Responses to July 10, 2020 Preliminary Plan redlines:

Redlines from preliminary plan LOI:

SHEET TITLE: SITE PLAN (NORTH)
SHEET NO. 2
2 OF 5 SHEETS
FILE NO. SP-19-006

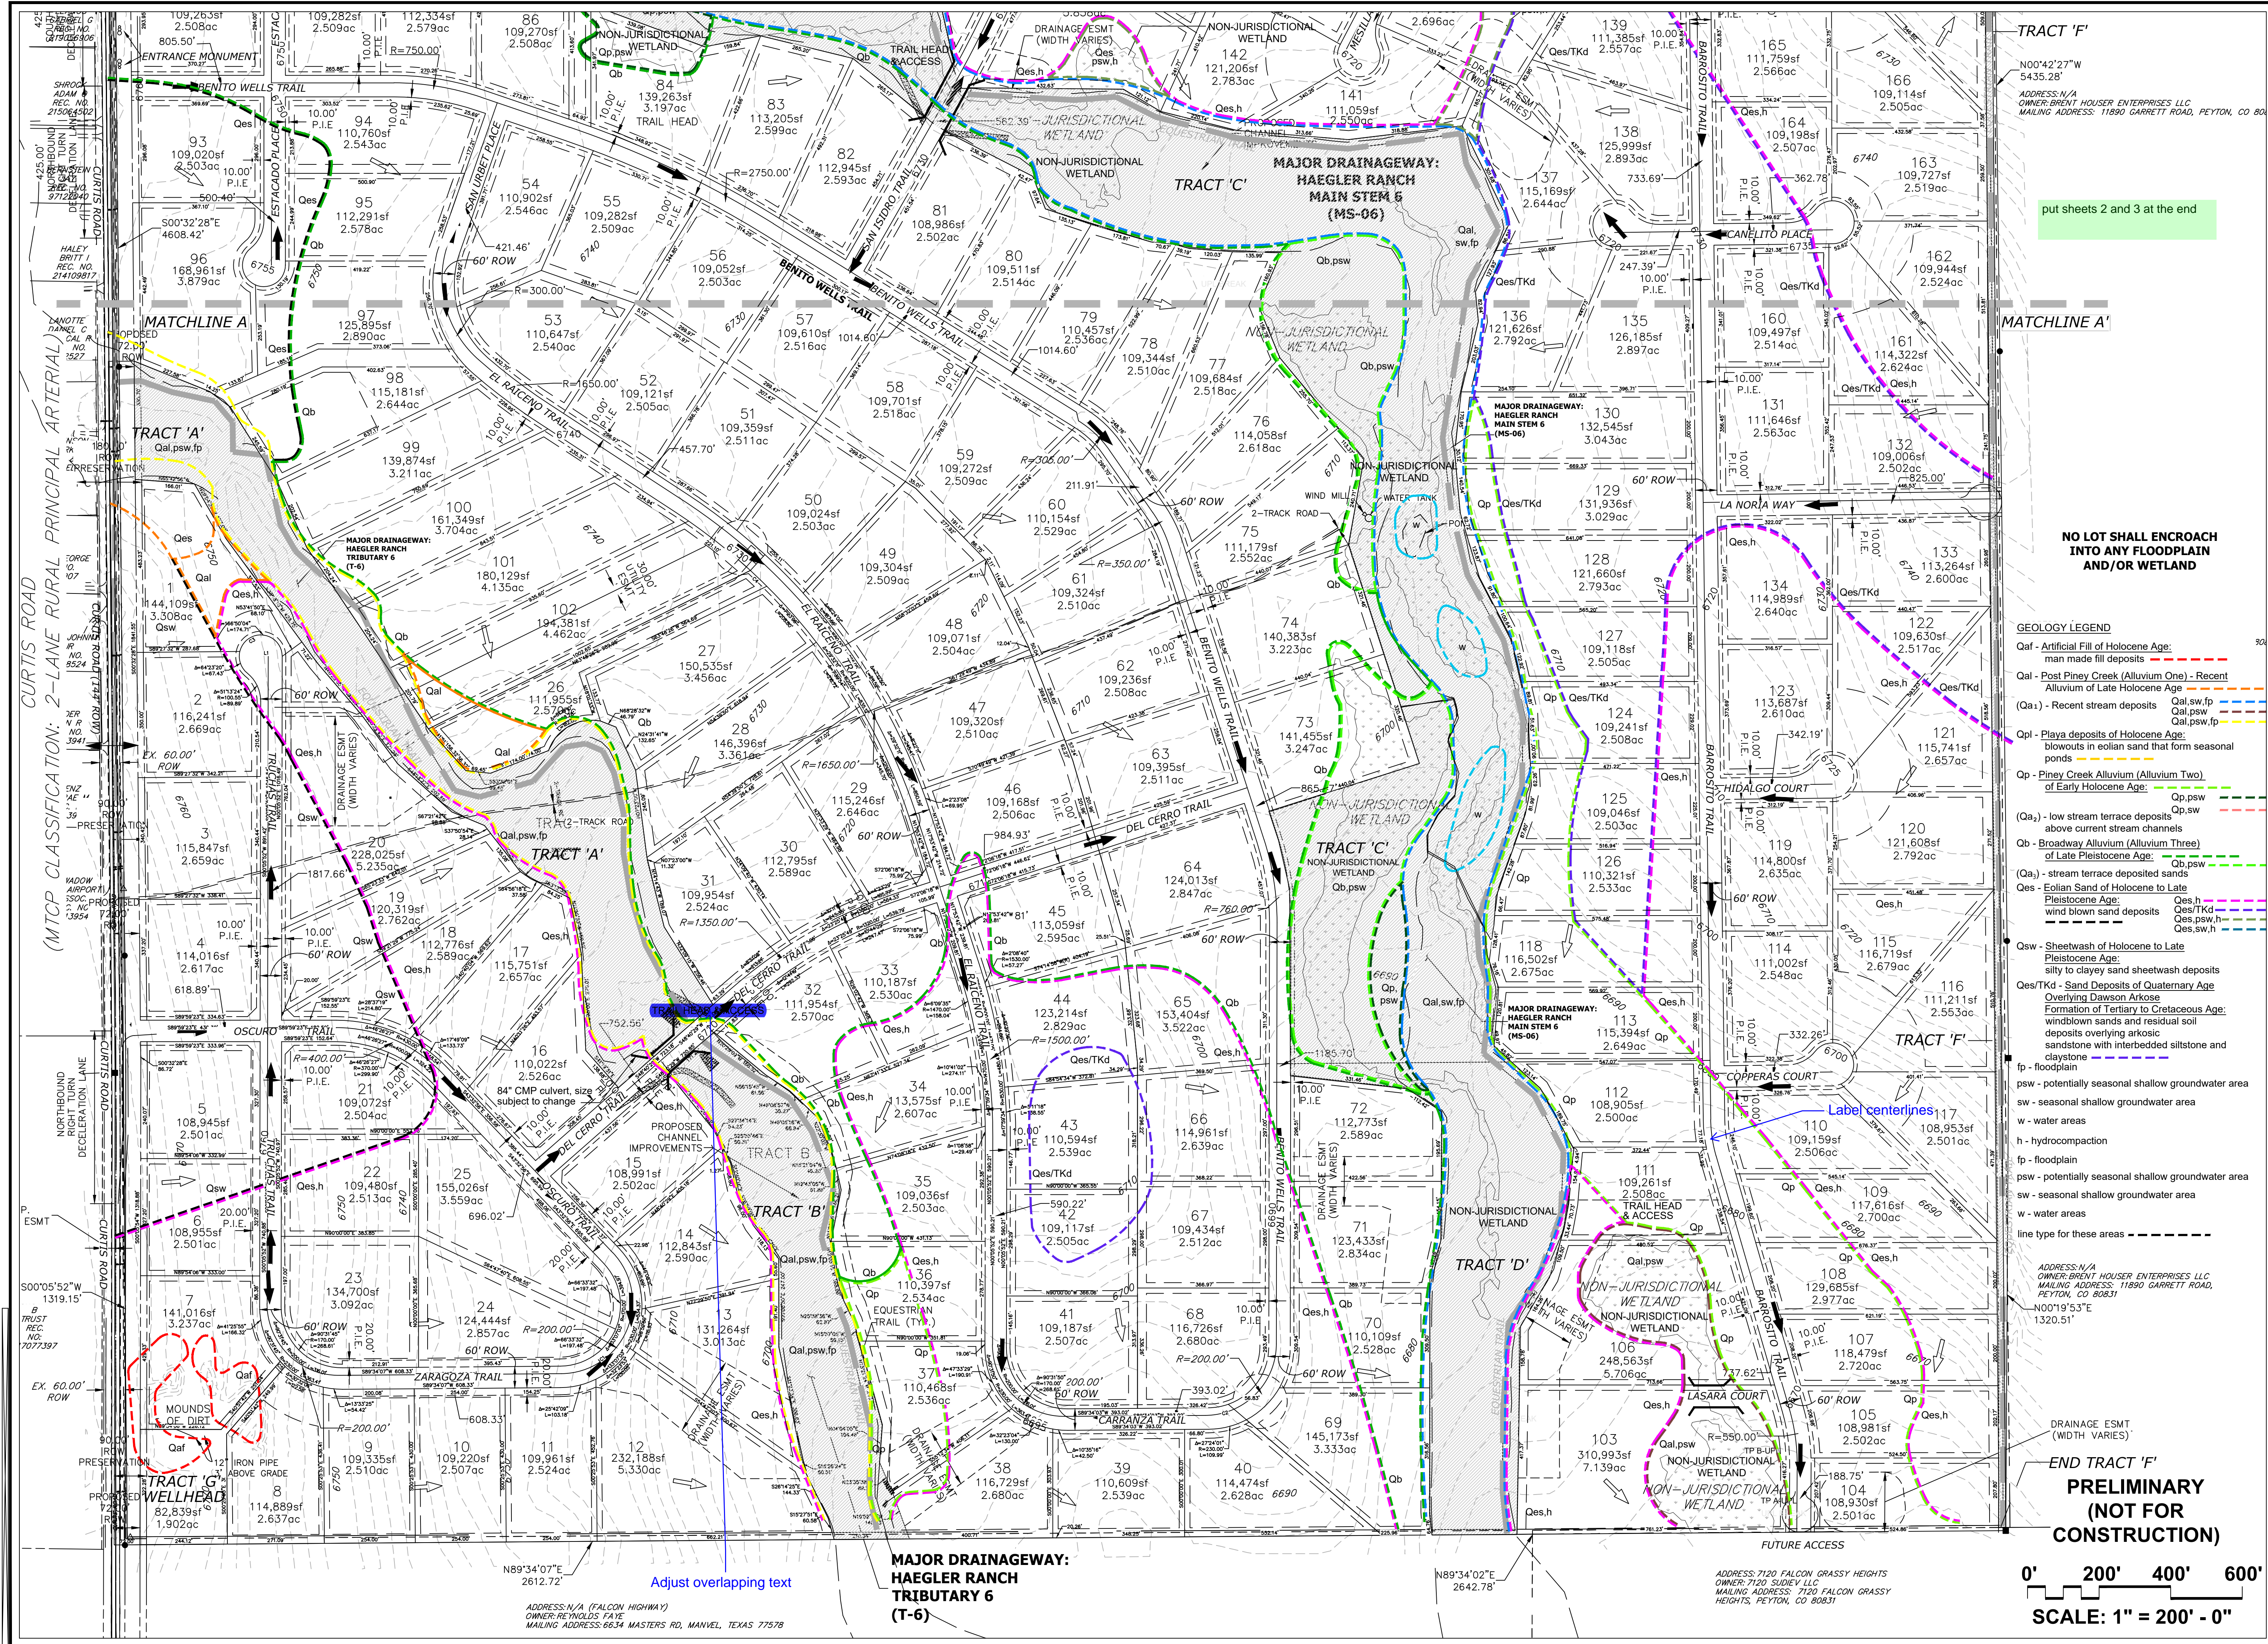
3. On sheet 2, phasing plan (north), County has five (5) remarks (two are duplicate, referring to the entrance monuments at two locations, north and west). 1.) Entrance monuments need to be outside of ROW in easements. Guman: The entrance monuments have been removed from the plans. 2.) With the text now lightened (gray) verify that hatching will not overwrite and everything will be legible when printed. Guman: The text was modified to ensure legibility when printed. 3.) Label approximate street grades. Guman: No change made to preliminary plan. A separate plan set titled “Roadway Geometry Plan” has been uploaded as an optional item. This plan set shows approximate street grades. 4.) Which name is correct? (This is in reference to the street commencing between lots 206 and 194 south from Barrosito Trail. Guman: Enumerations routinely requires that a road that nearly approximates a 90° turn requires a change of name. Our understanding of the requirement is for fire response accuracy.

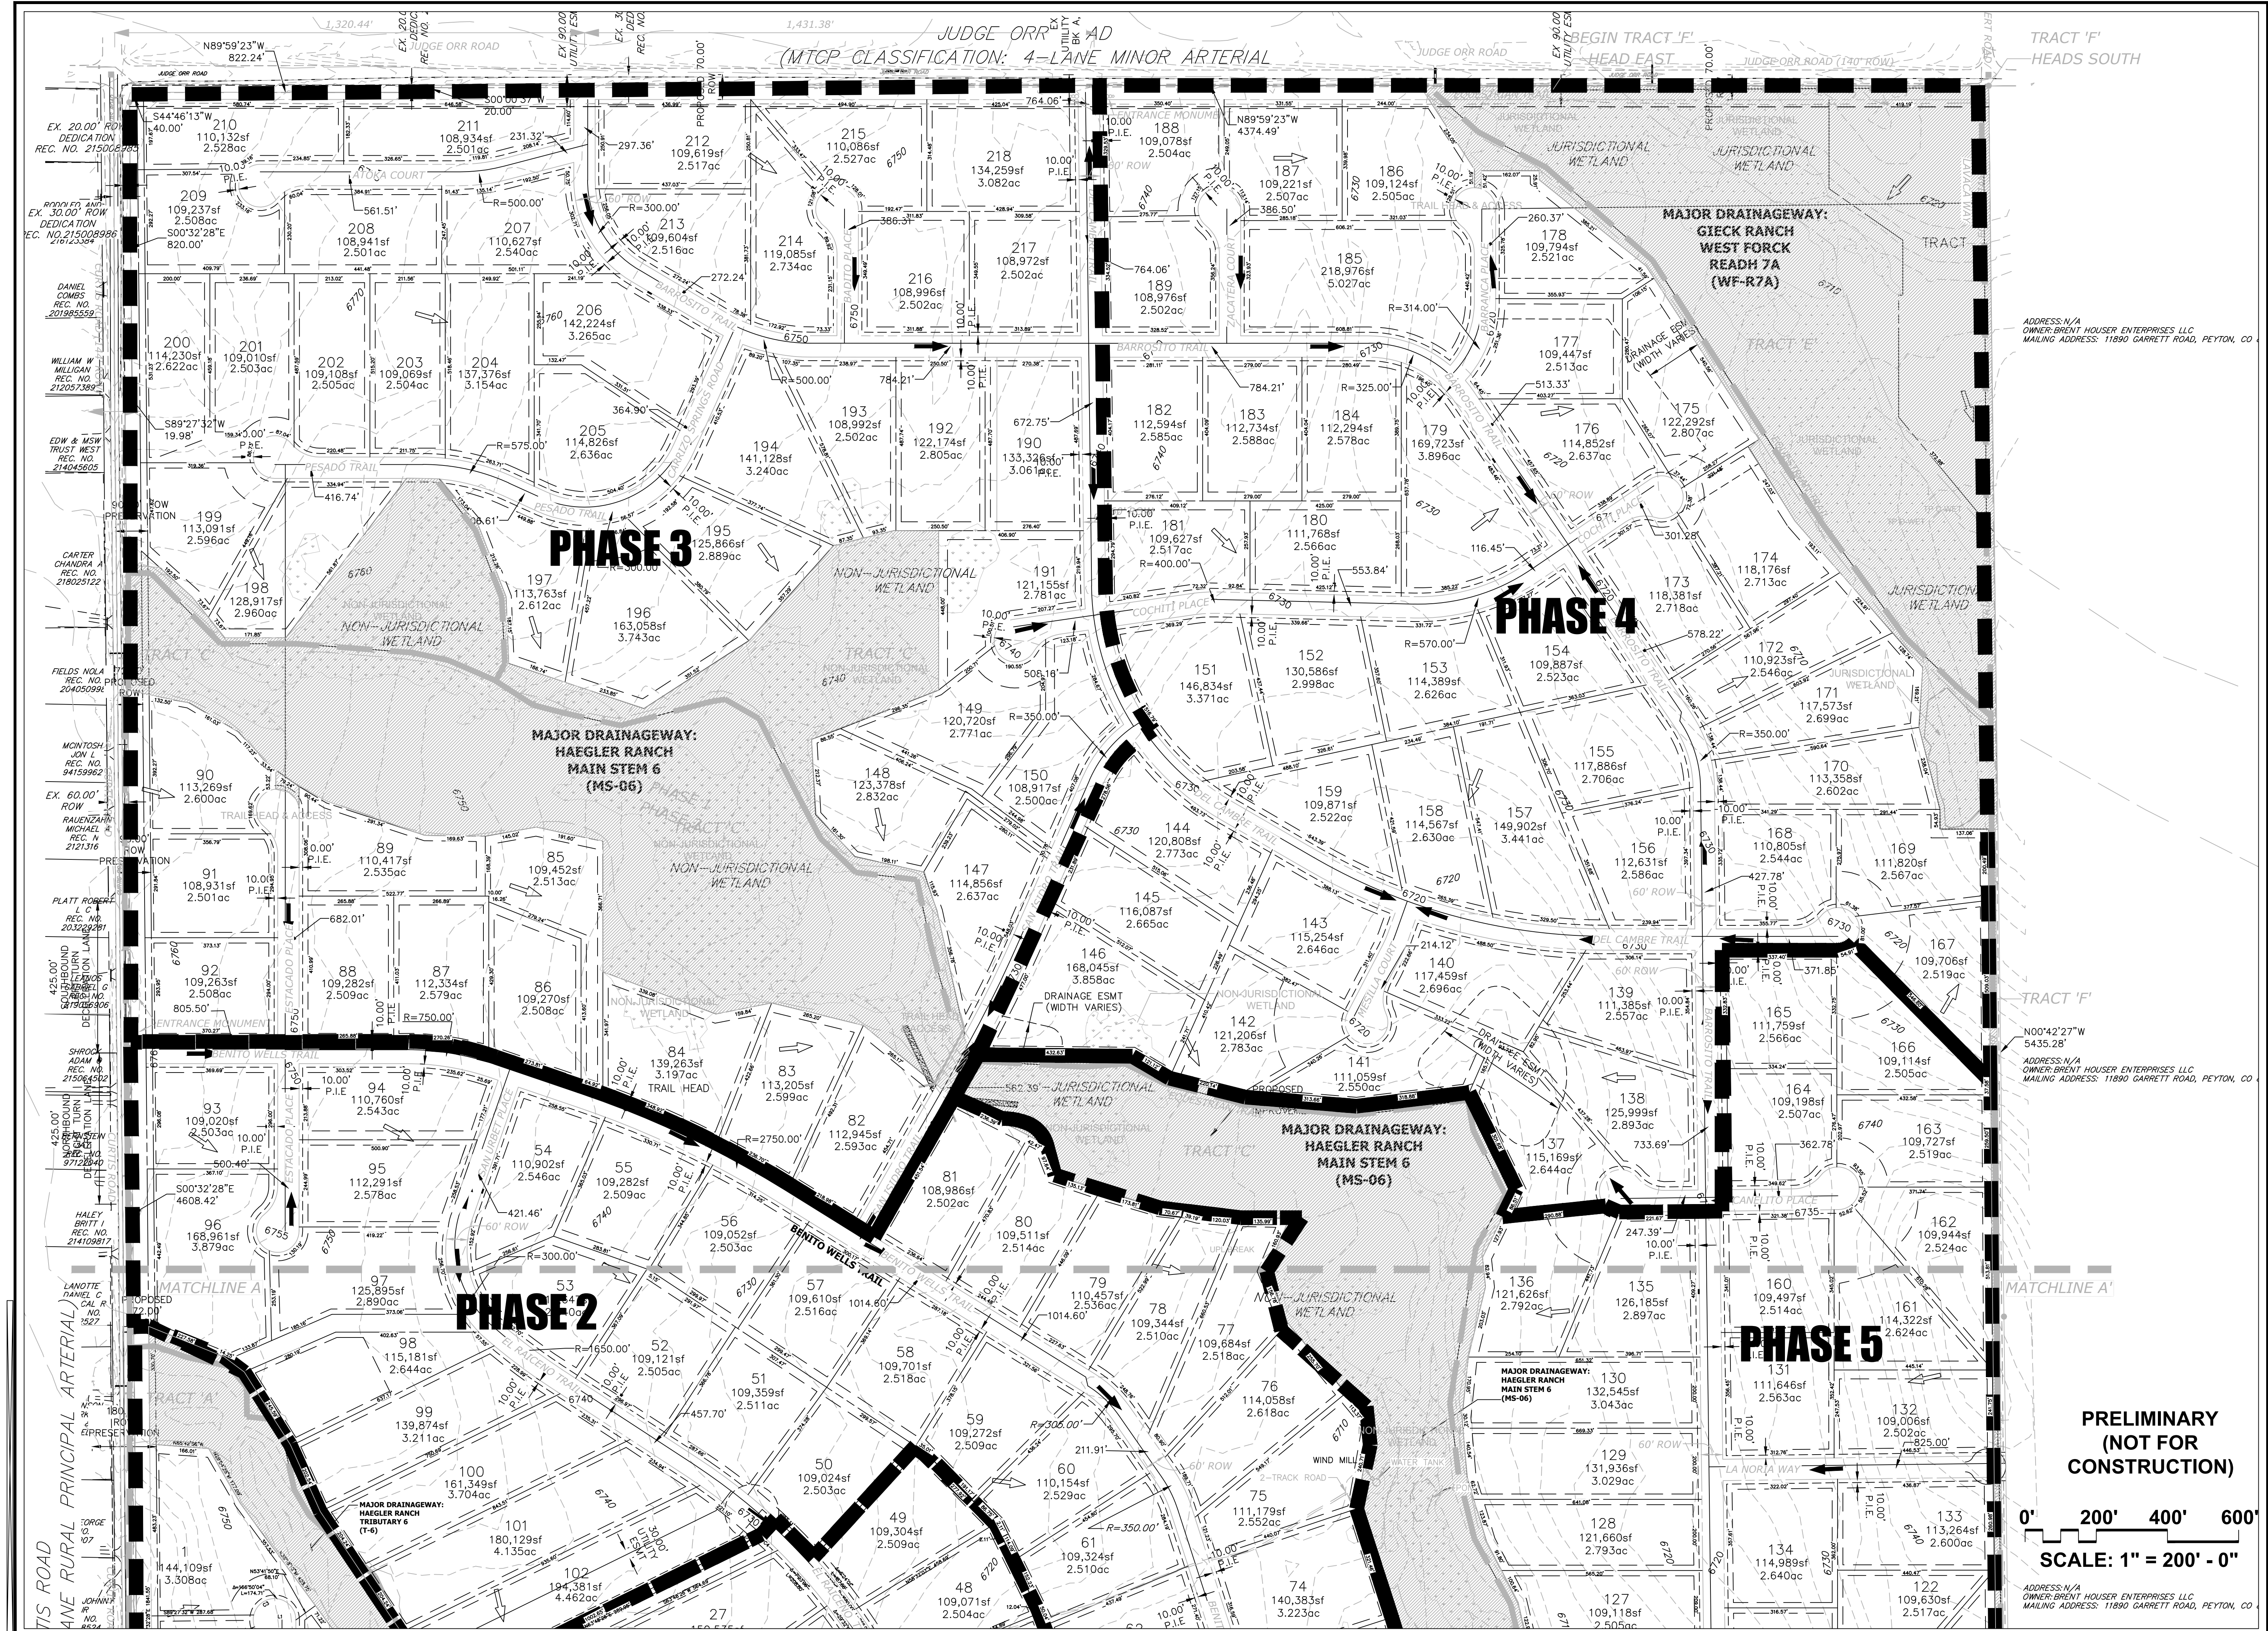
4. On sheet 3, phasing plan (south), County has a single comment. Label all centerlines radii. Guman: No change made to preliminary plan. A separate plan set titled “Roadway Geometry Plan” has been uploaded as an optional item. This plan set shows all centerlines’ radii.
